NEW TRAFFIC CONTROL SIGNAL PLAN Mast-Arm Traffic Signal Plan Sheet Marksheffel Road & Lorson Boulevard

LSC Responses to Comments

Marksheffel Road_Lorson Blvd. - Signal Design

Mast-Arm Traffic Signal Plan Sheet

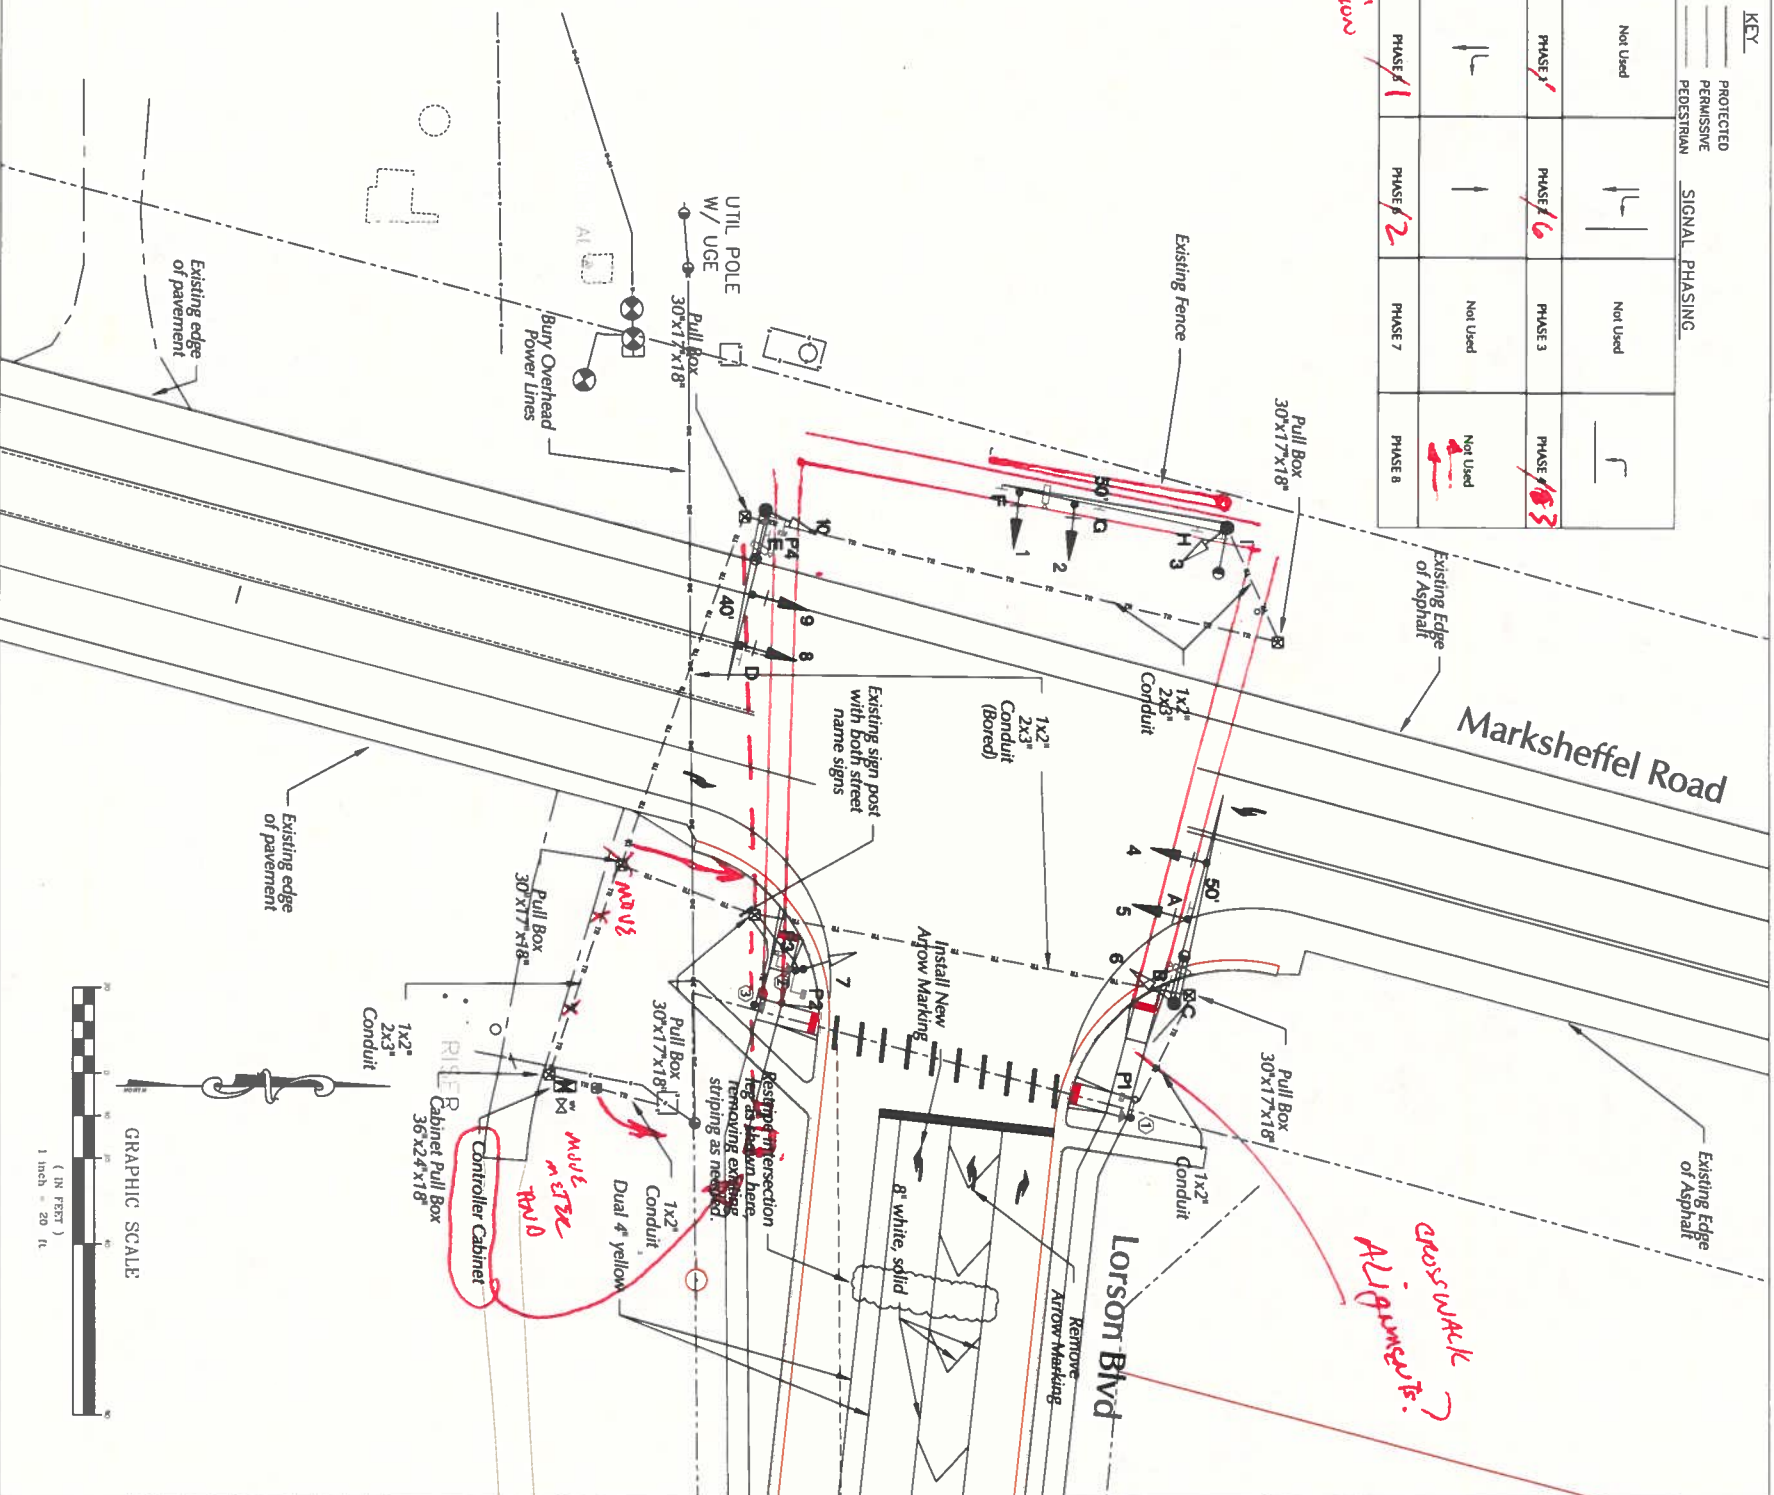
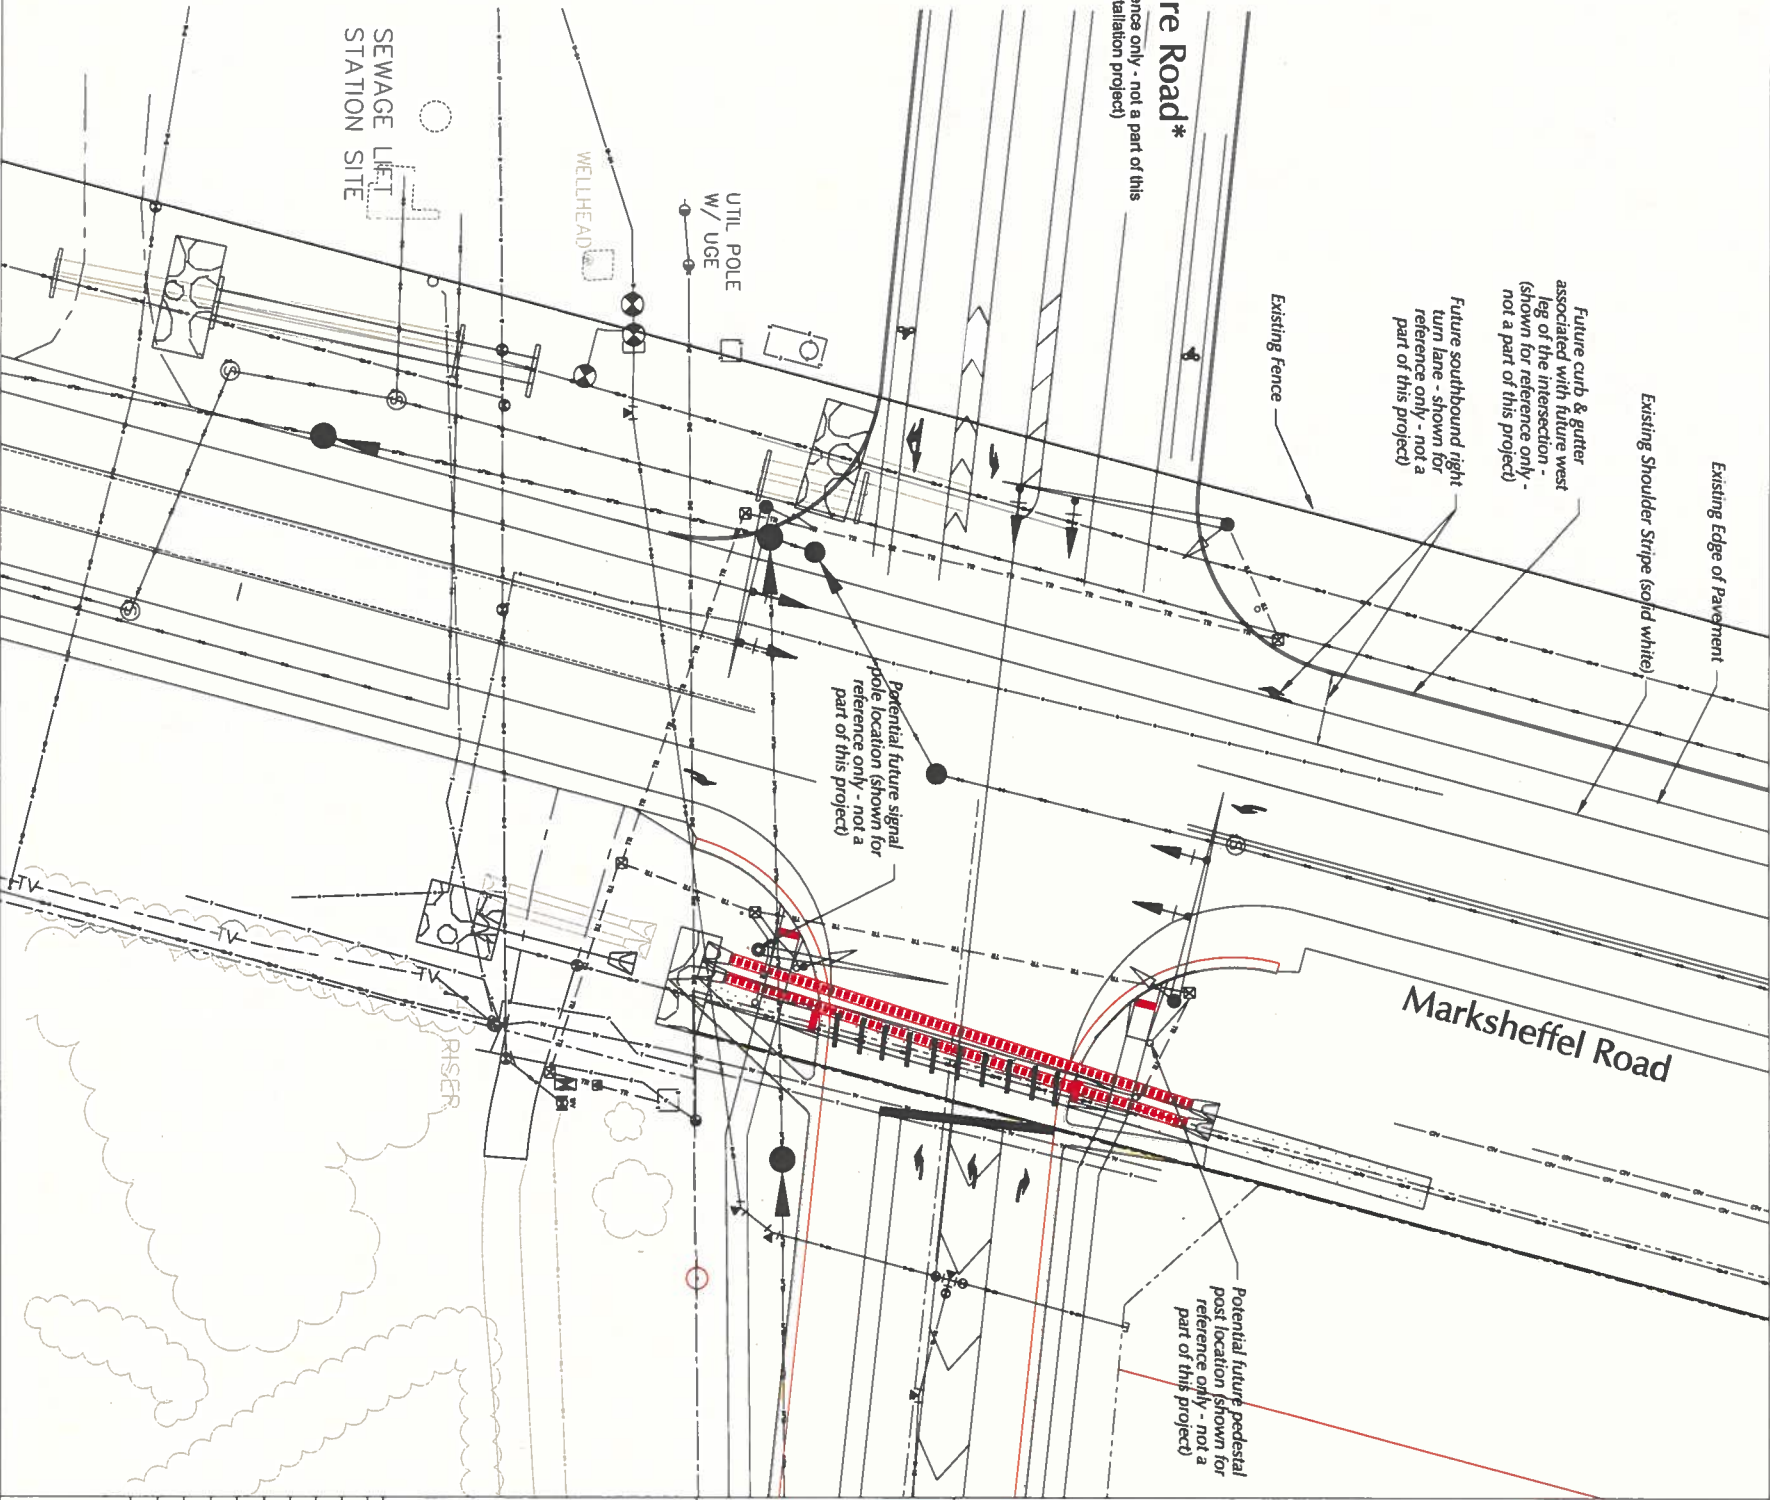
[Label structures](#)

[Show and label all ROW](#)

LSC Response: Added as requested.

LSC Response: Added as requested.
